From: Amanda Scholes on behalf of Planning.Responses
Sent: 31 August 2018 08:35
To: Planning Scanning
Subject: FW: LU/191/18/DOC Compliance with Condition 8 Cycle Storage, Land to the North of Old Mead House

From: Colin Giddings
Sent: 30 August 2018 13:26
To: Anita Gardner
Subject: RE: LU/191/18/DOC Compliance with Condition 8 Cycle Storage, Land to the North of Old Mead House

Subject: LU/191/18/DOC Compliance with Condition 8 Cycle Storage, Land to the North of Old Mead House

Standard timber 1800mm x 2400mm
as provided to each plot

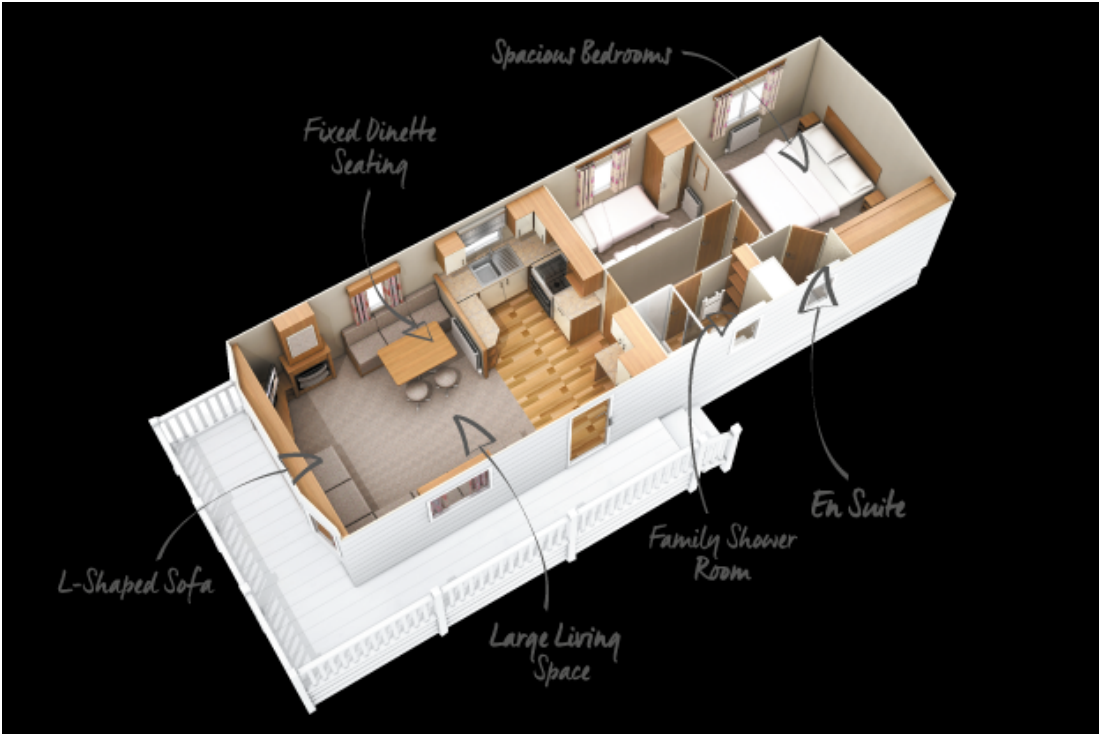
I confirm that there is no issue with the timber sheds on the individual plots as shown as, although they are of timber construction, they are not within the separation distances required for safety reasons under the licensing regime; the correspondence from MSD dated June, added to the portal 17/8/2018 clarifies the confusion. The mention of a cycle shed appeared to be a separate item located elsewhere -- perhaps to do with then office? -- but not marked on the plans. The MSD letter clarifies that each individual timber storage shed is 'the cycle shed'.

As there is no separate timber storage shed (for cycles or other purposes) proposed I have no concerns in this regard.
